SYDNEY INTERNATIONAL CONVENTION, EXHIBITION AND ENTERTAINMENT PRECINCT (SICEEP)

TRAFFIC AND TRANSPORT ASSESSMENT ADDENDUM REPORT – SSD 5752

LEND LEASE PTY LTD

Date 27 June 2013

AUSTROADS 2006 19.0m SEMI -
01 OUT TO DARLING DRIVE @ 5km/hr
1 : 500

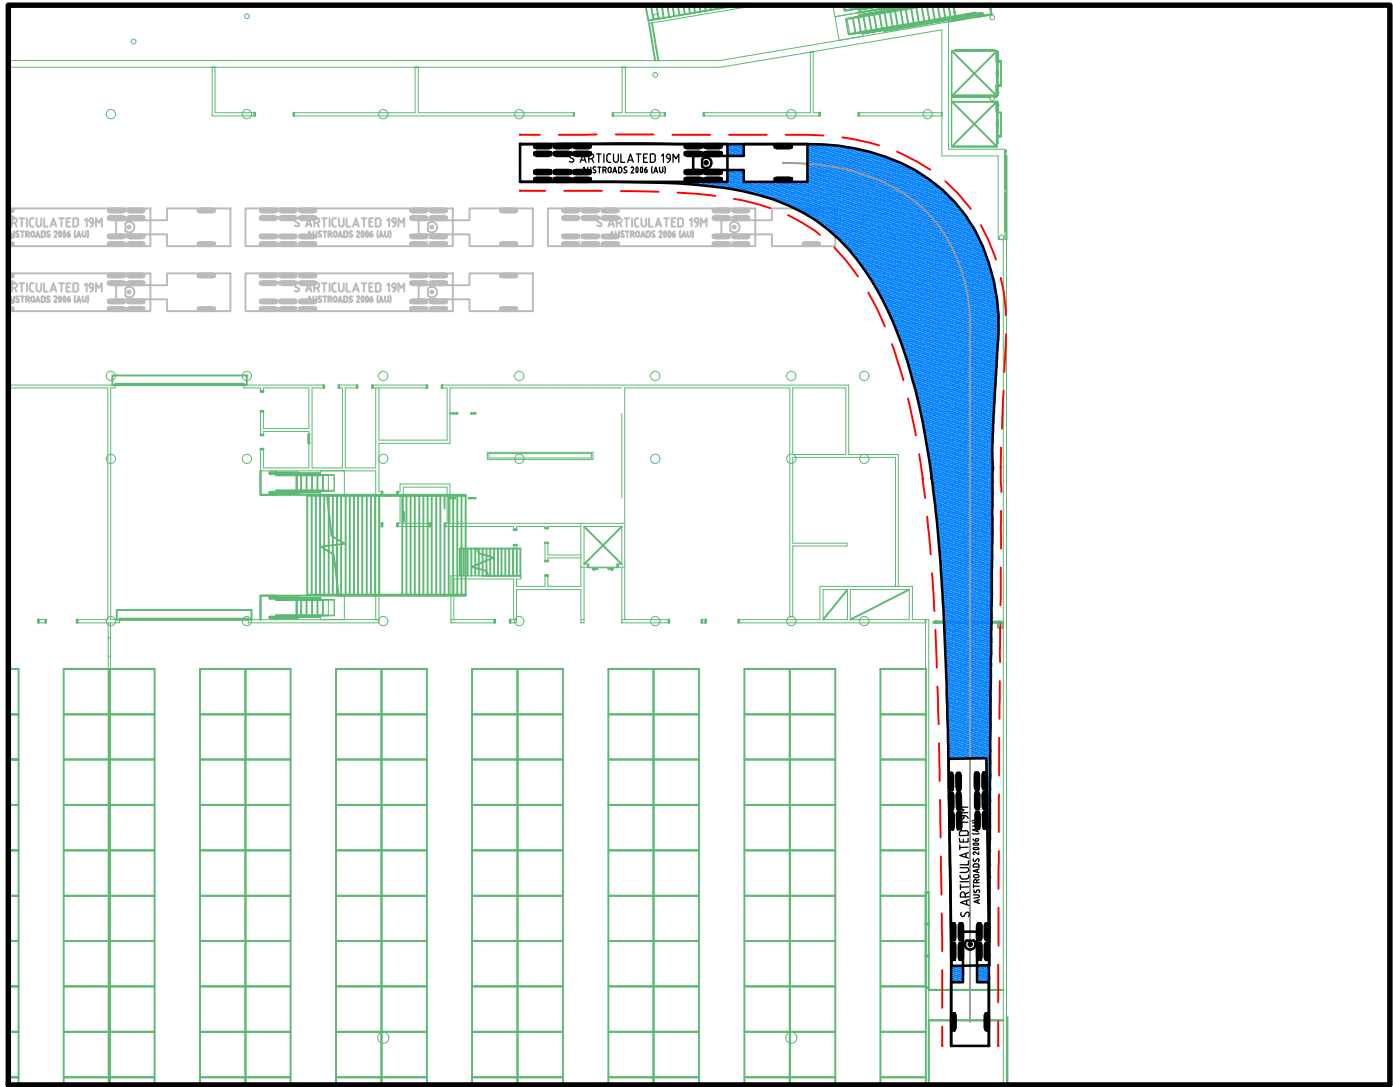
Category	Item	Issue Description	Response and Relevant Section of Addendum Report (where applicable)
Vehicular Access	14	The turning path for 19m articulated trucks exiting the Exhibition Centre loading dock onto Darling Drive crosses over two lanes of traffic and the footpath. Demonstrate how safe truck access can be achieved by either reconfiguring the dock or the angle of access or providing an acceleration/merge lane. In this regard a revised turning path is required to demonstrate how trucks will safely enter and exit the Exhibition Centre loading dock.	<p>Trucks entering the Exhibition Centre lower and upper level loading docks are provided with a dedicated slip lane along Darling Drive. Trucks leaving the upper level loading dock will egress in the same direction of traffic as southbound traffic on Darling Drive, via a dedicated exit lane. Trucks exiting the lower level loading dock have to exit using both southbound lanes of Darling Drive. However, the majority of truck movements into and out of the Exhibition Centre loading dock facilities will be made in off-peak times, during the night or very early morning.</p> <p>Swept path analysis of trucks leaving the lower Exhibition loading dock will be undertaken during the detailed design stage, to look at the finer turning movement of this swept path and to ensure adequate protection to pedestrians in the vicinity of this loading dock egress location.</p> <p>Please see preliminary swept path movement below:</p>  <p>AUSTRoads 2006 19.0m SEMI - 01 OUT TO DARLING DRIVE @ 5km/hr 1:500</p>
